Online Comment

Application H16-0101-22
Location 10 HAVERFIELD ROAD SPALDING PE11 2XP
Proposal Demolition of rear hall and erection of two storey extension to incorporate ground and first floor halls, kitchen, food bank and function rooms.

Name Greg Watkinson
Address Conservation Officer

Date Submitted 08-03-22
For/Against Objections

DRAWING: PROPOSED ELEVATIONS

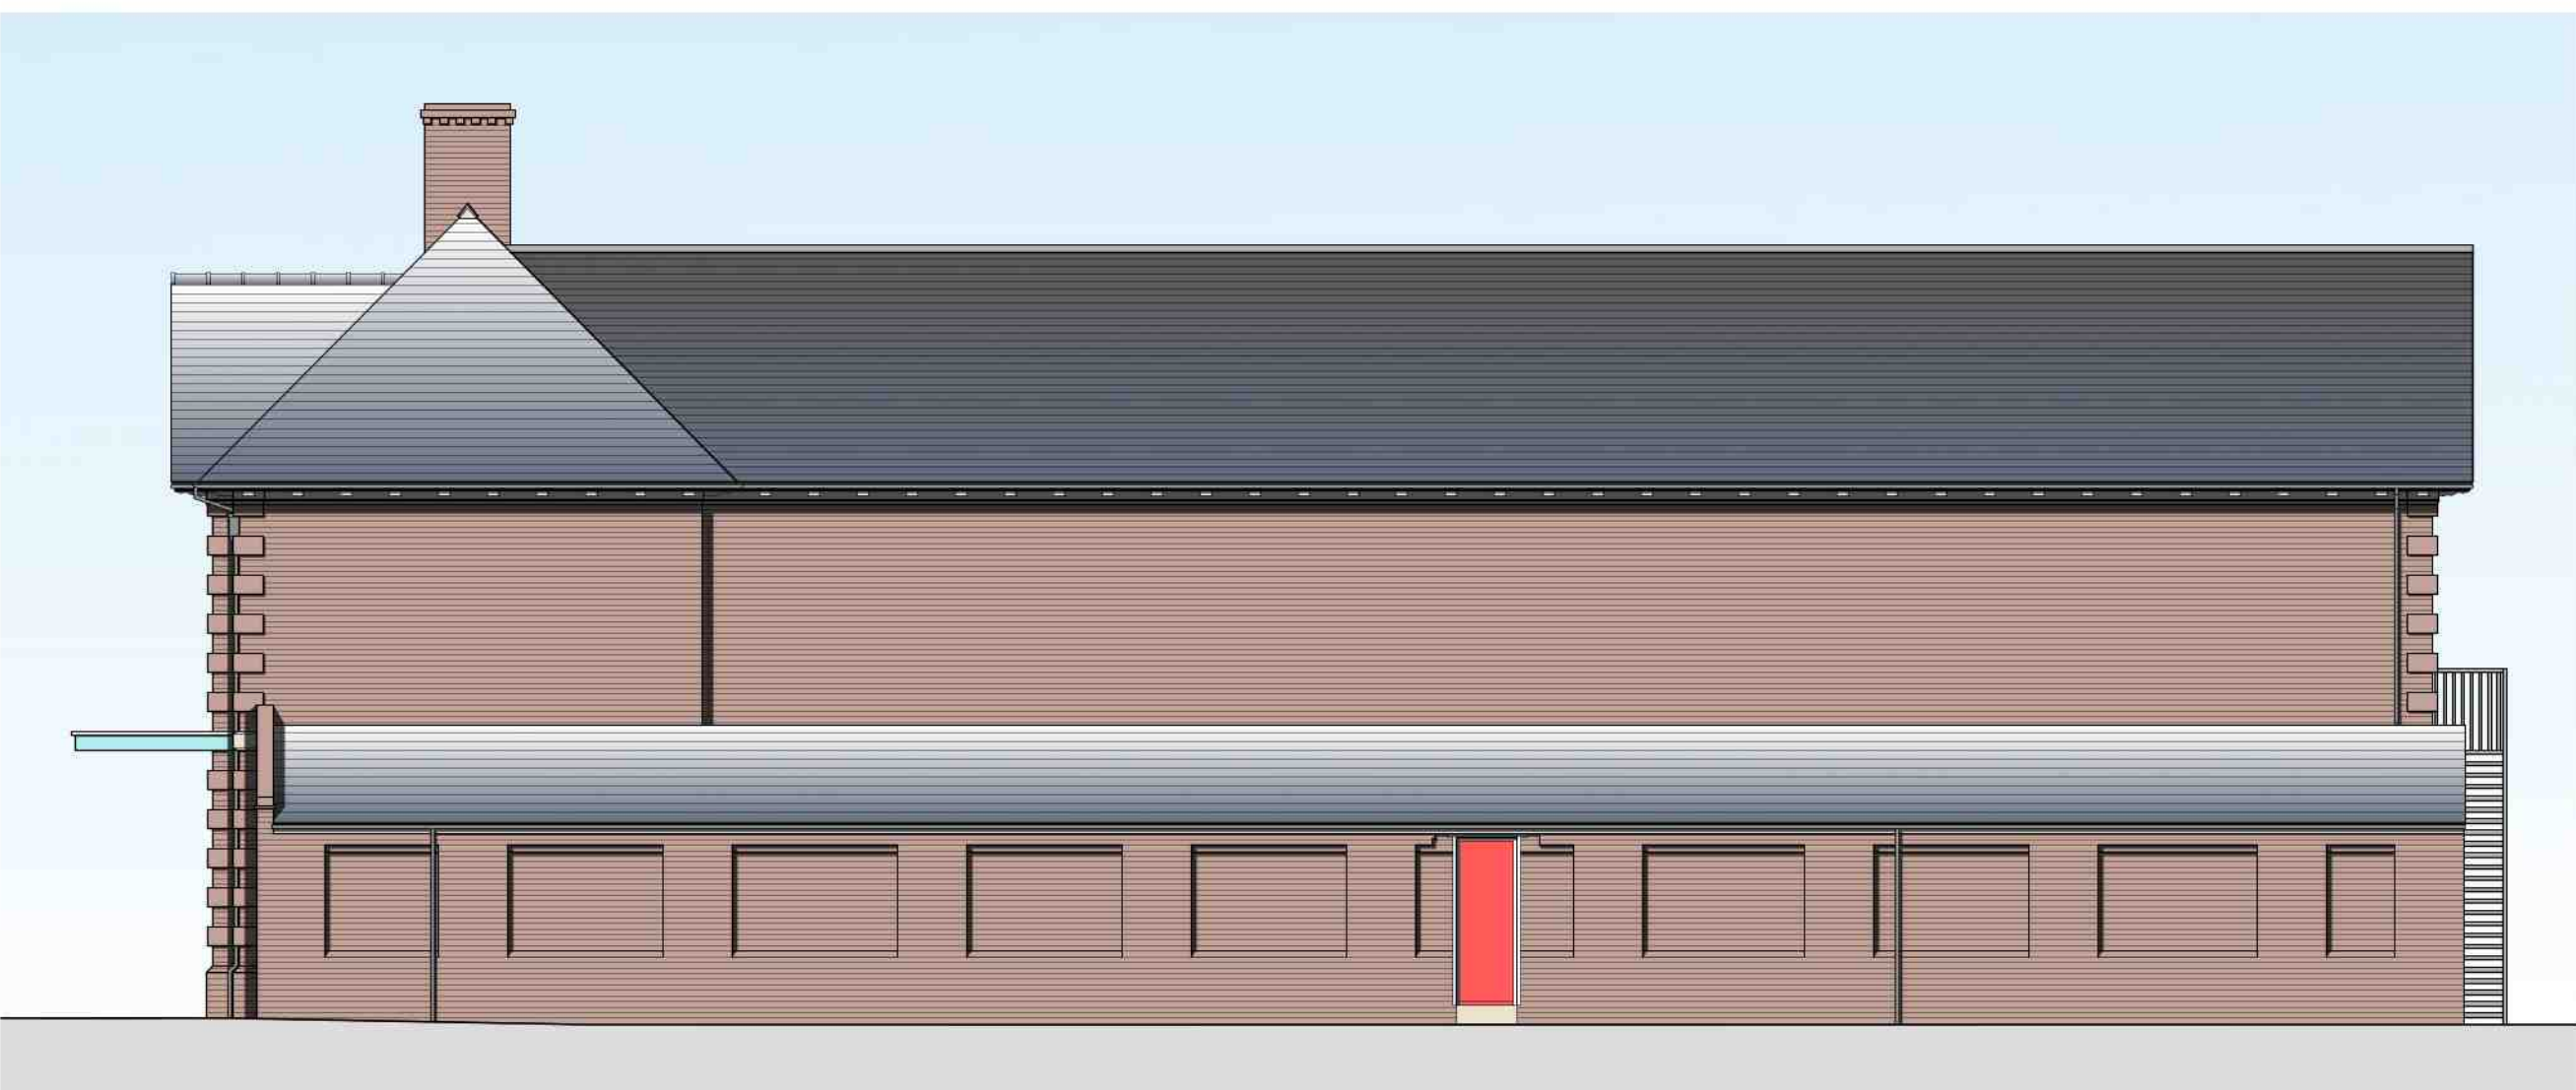
I write to confirm that in this instance, I object to this proposal. The proposal site itself is a non-designated heritage asset, yet the designs proposed by do not take the architectural desirability of this site into account, and would appear at odds in terms of not only style, but also scale and massing, representing a proposal which would be detrimental in terms of character to both the host heritage asset and the wider Conservation Area setting.

The large, featureless walls give the appearance of a thoroughly modern, utilitarian wing which would completely outscale the original property, making it appear subservient in comparison. Whilst the building is not a listed property, it is a non-designated heritage asset, and within a central position within the Conservation Area for Spalding. This proposal would be significantly out of sorts within the conservation area setting in terms of harmony with the historic environment as well as scale and massing.

I therefore suggest that in its current state, this application is not suitable for approval, by virtue of its scale, design and lack of appropriate regard for the character of the immediate area or the host property.
